Request for Information 1, 7833 SE 28th St--revised
Project #DSR20-010 & SEP20-005

Per the comment letter dated February 16, 2021, below is the response to this comment letter along with the revised and updated plan set.

EXTERIOR ELEVATIONS

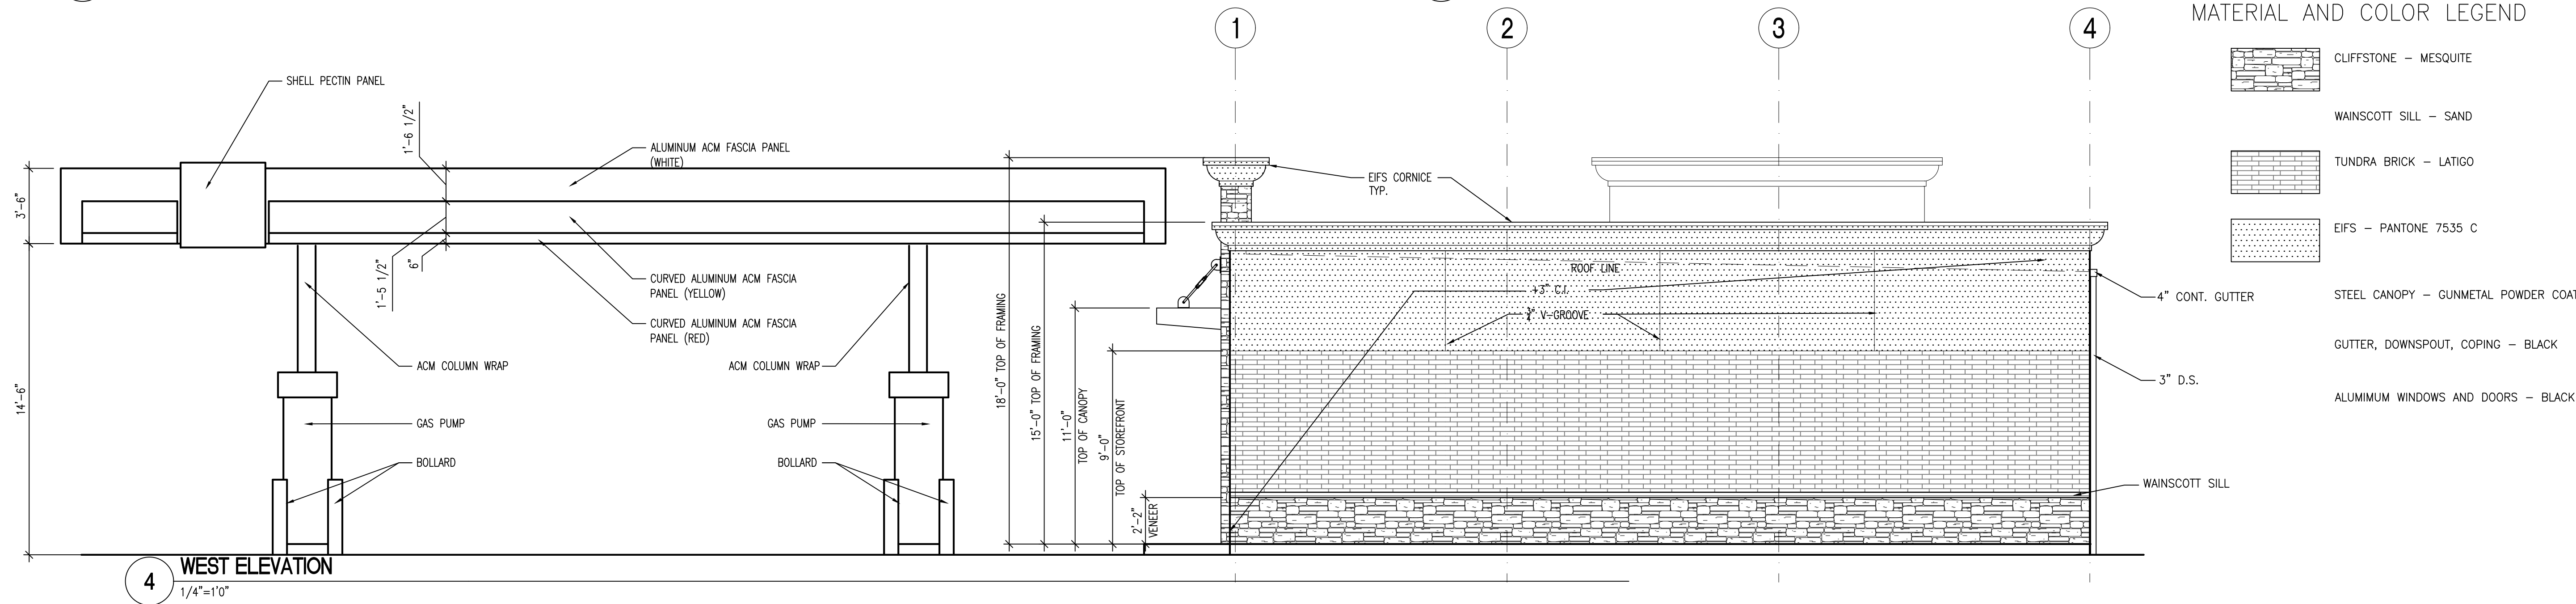
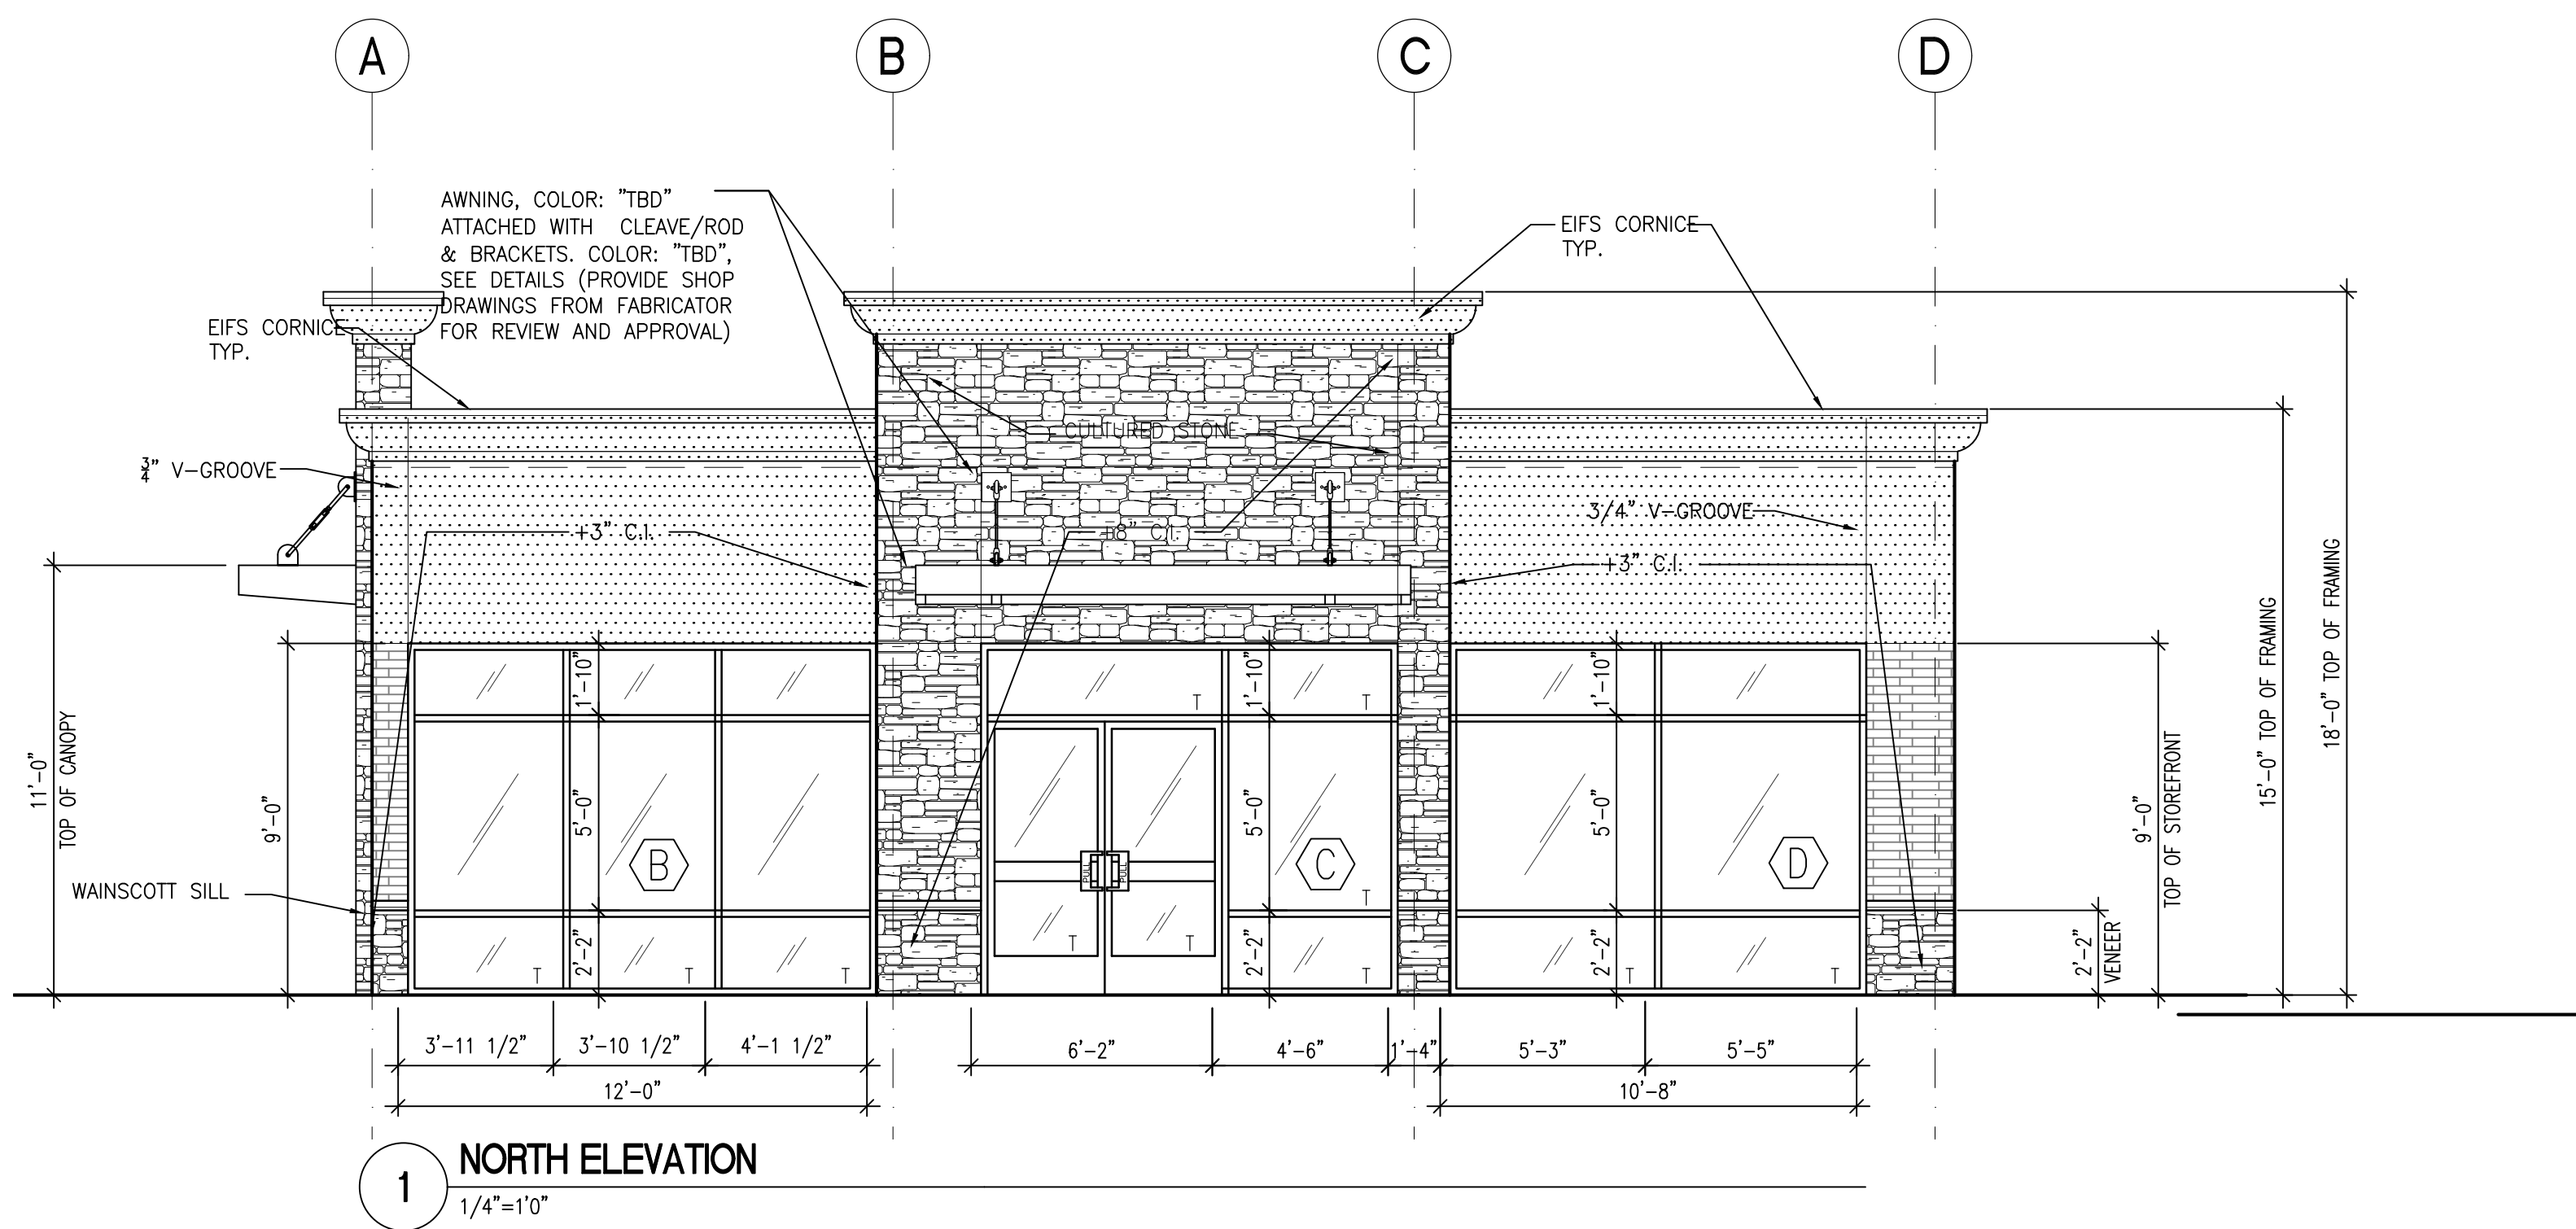
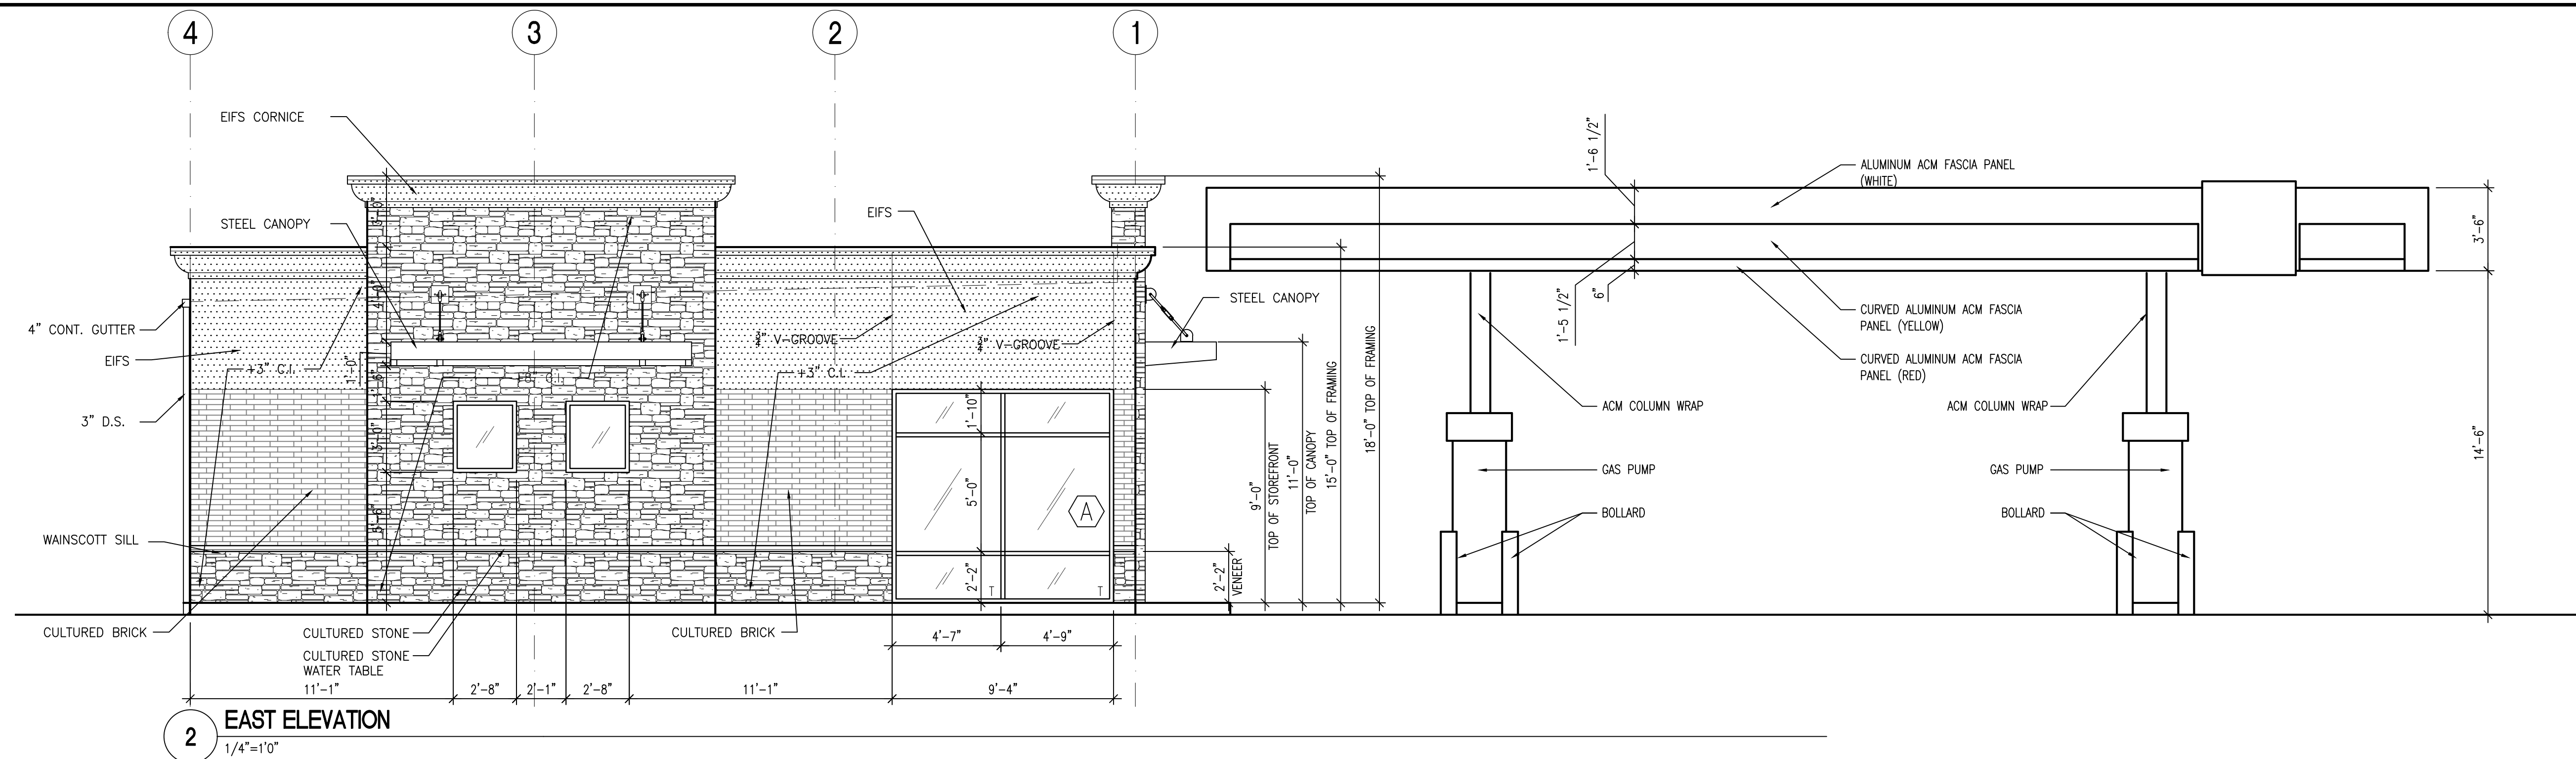
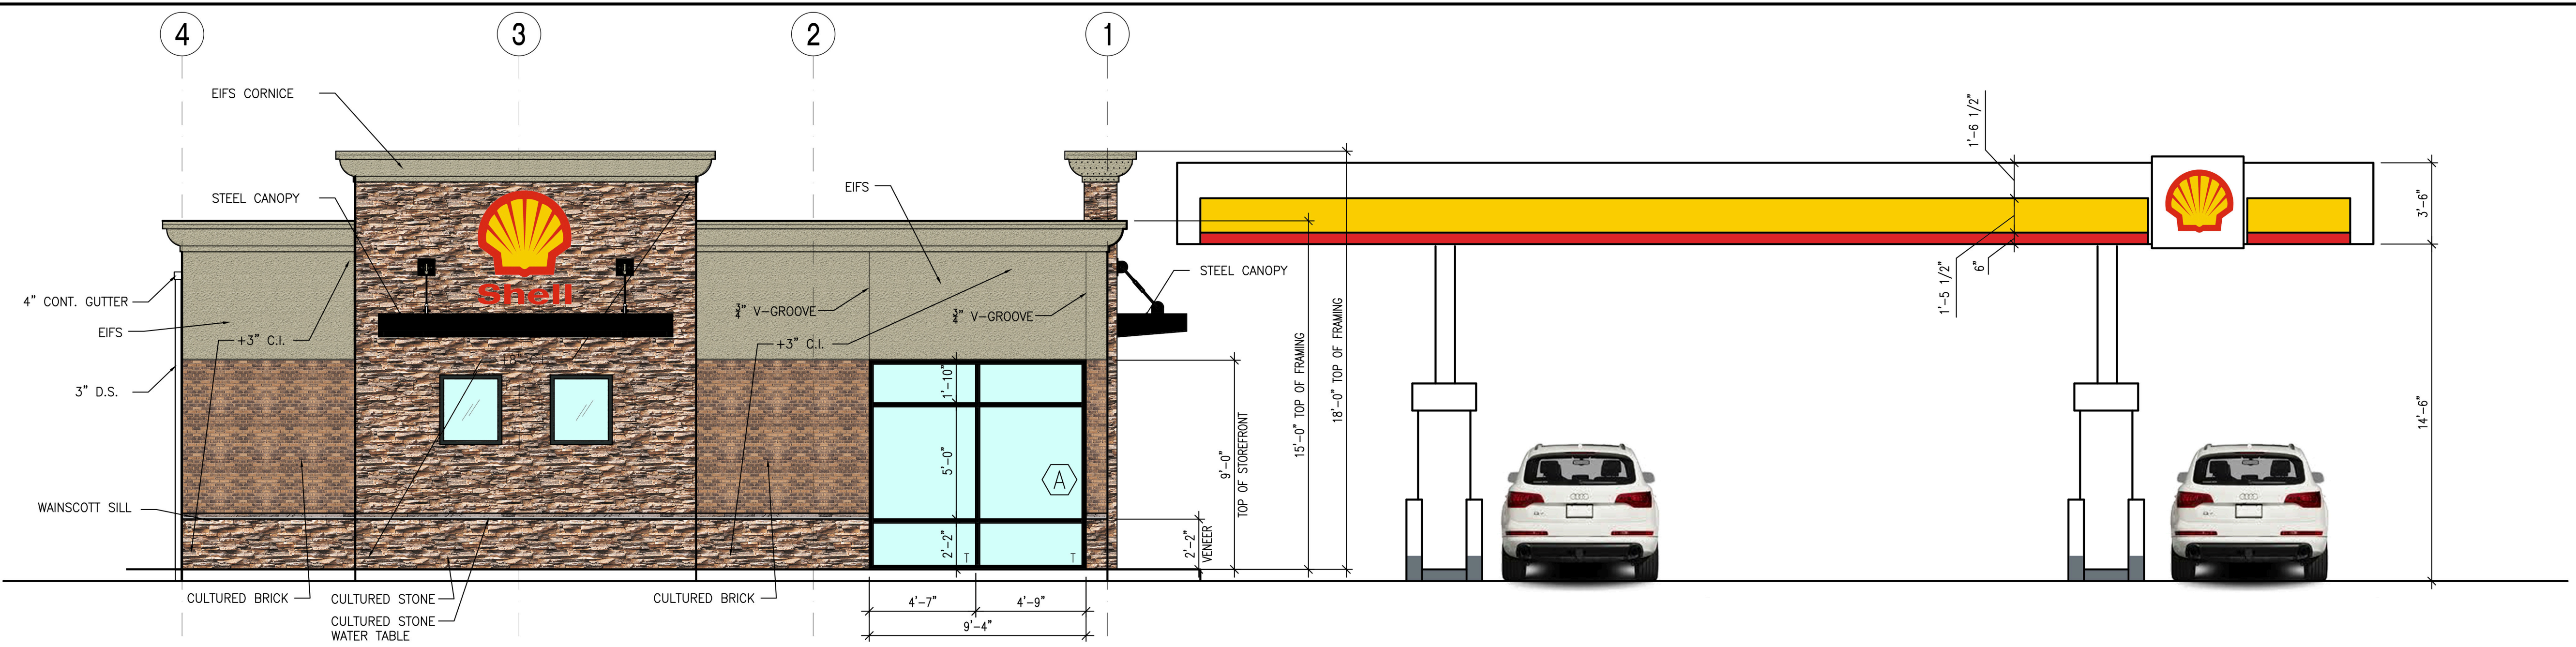
2. Sheet A2.1 shows a blank wall on the east façade that exceeds the size allowed by MICC 19.11.100(B)(5). Please revised the design to meet this standard. (Note that MICC 19.11.100 encourages transparent facades; adding transparency would be a way to fulfill both code standards.)

3. See updated east elevation with increased window area.
4. Please provide information (e.g. in the form of a project narrative) describing how EIFS is high quality and durable, meeting the standards in MICC 19.11.110(B) – Materials and Color. Note that EIFS is specifically called out as an undesired materials in MICC 19.11.110(B)(7).
